REF: 12 BRIDORLEY CLOSE, PAGHAM - P/87/08

Further to our recent telephone conversation, please find enclosed a revised drawing for the above project which we submit in respect of the non material amendments required to the consent.

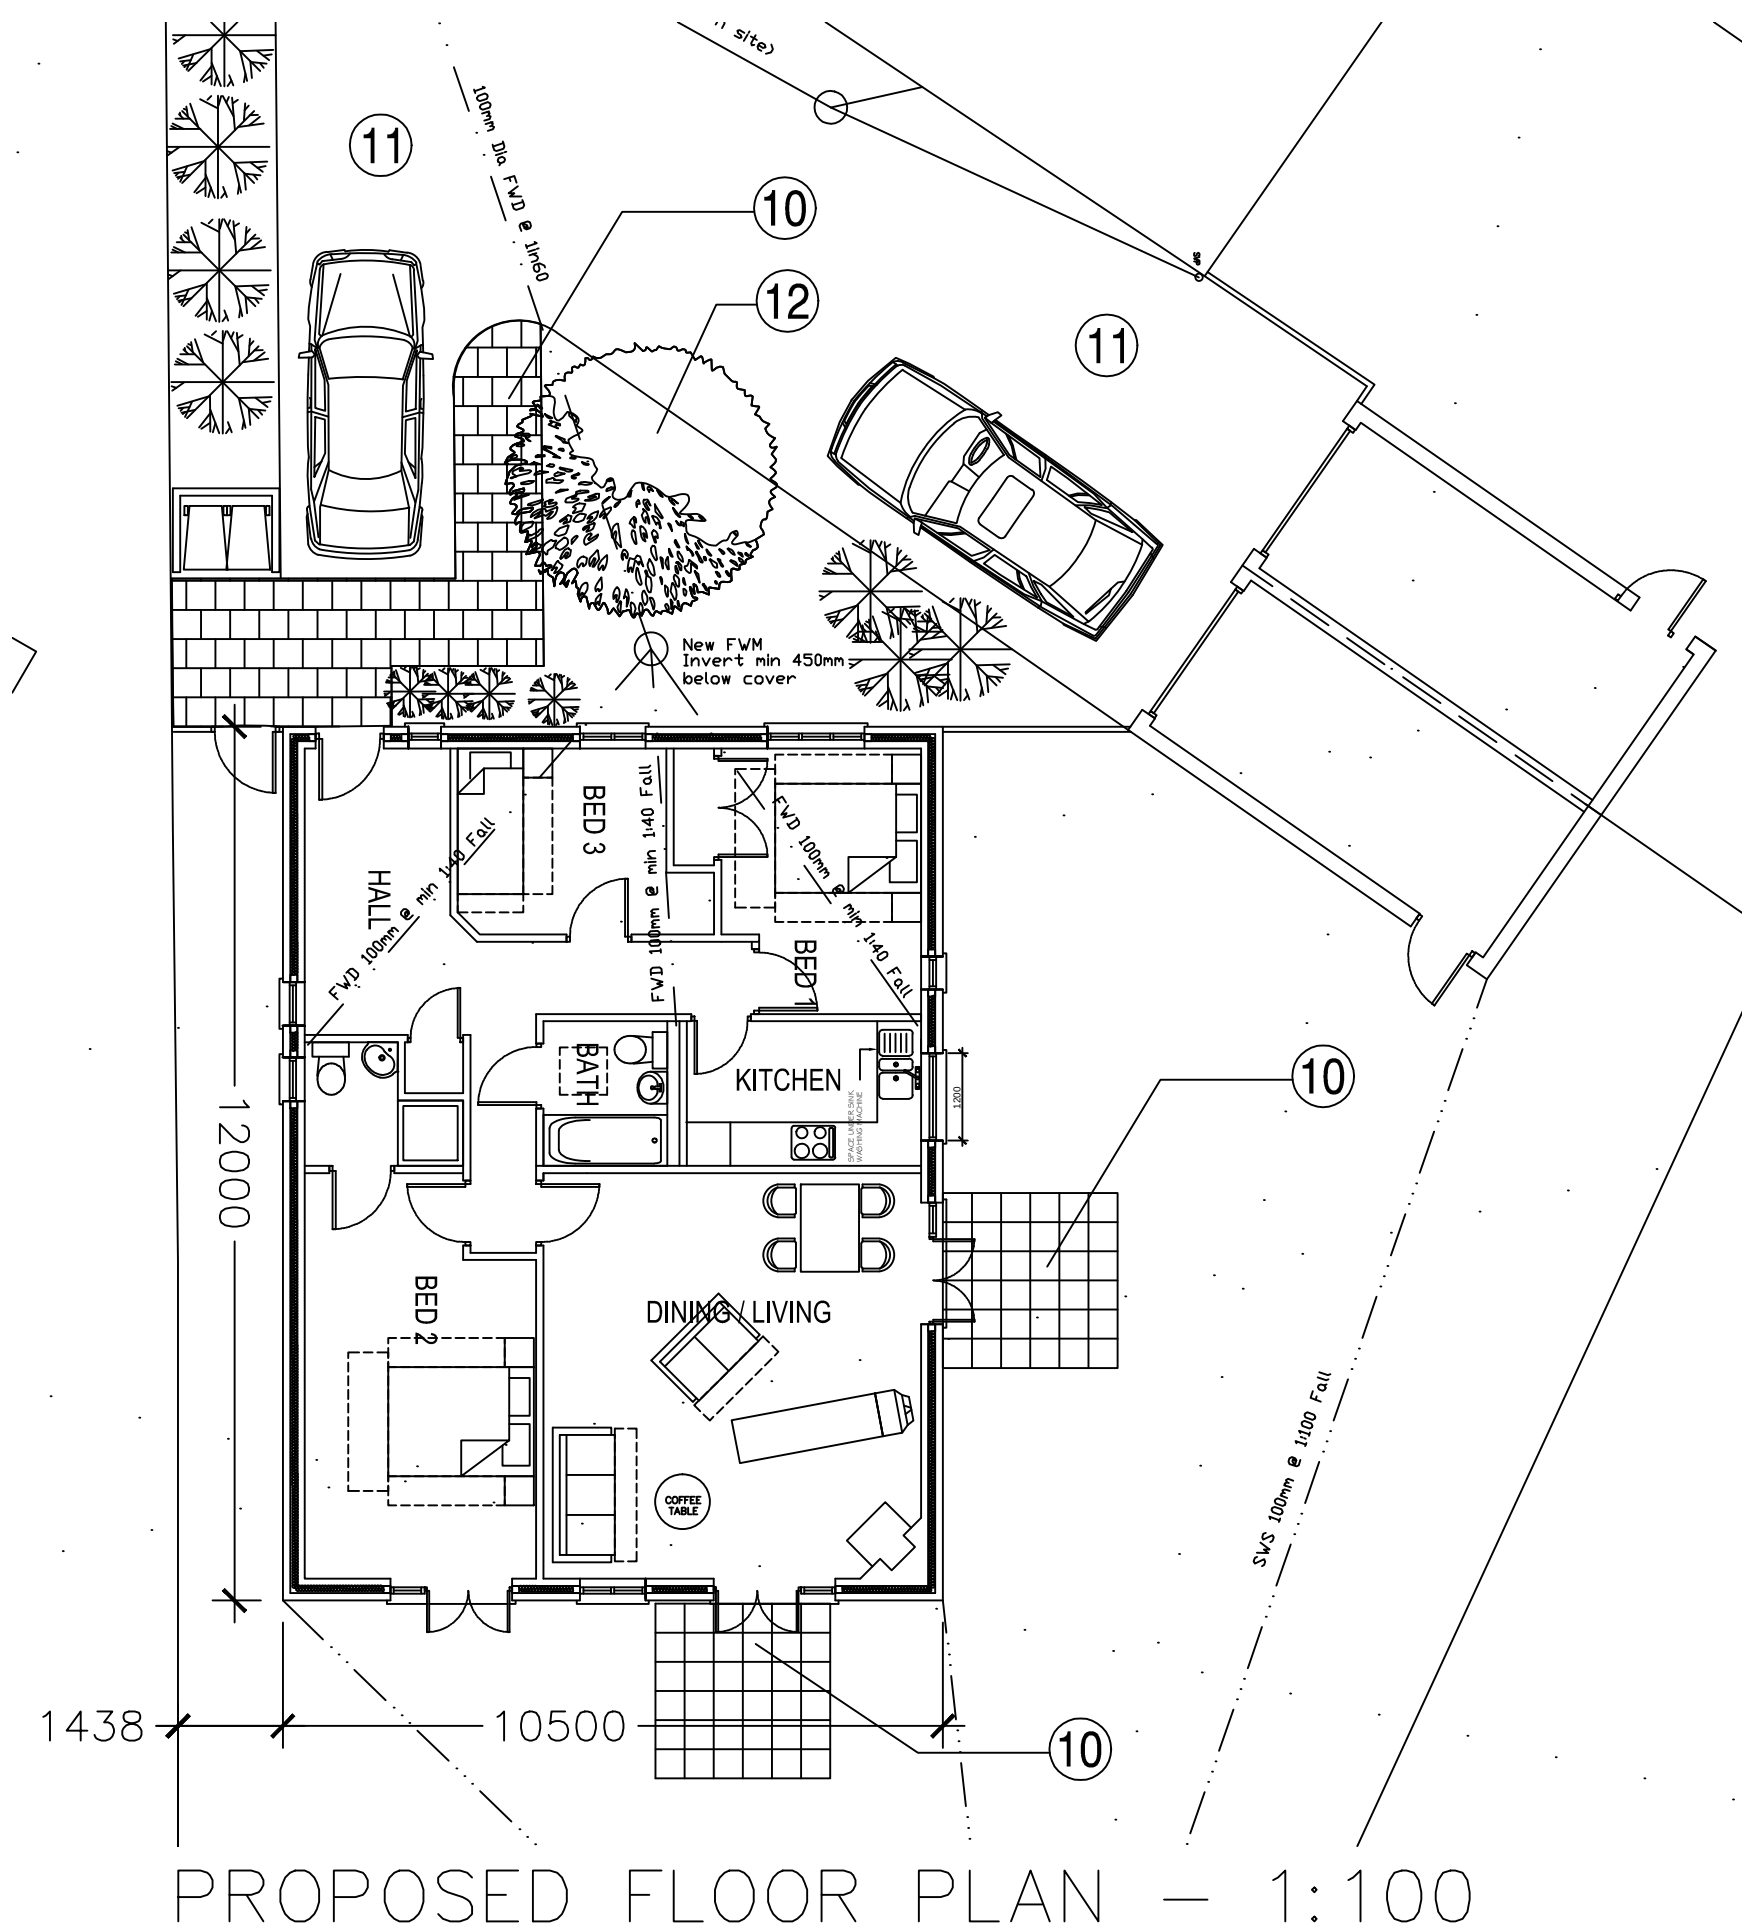
Velux Windows - The two velux windows on the flank elevations have now been included on the revised drawing enclosed.

Garage Location - The relationship of the garage building to the boundaries (as constructed) is now accurately represented on the revised drawing enclosed.
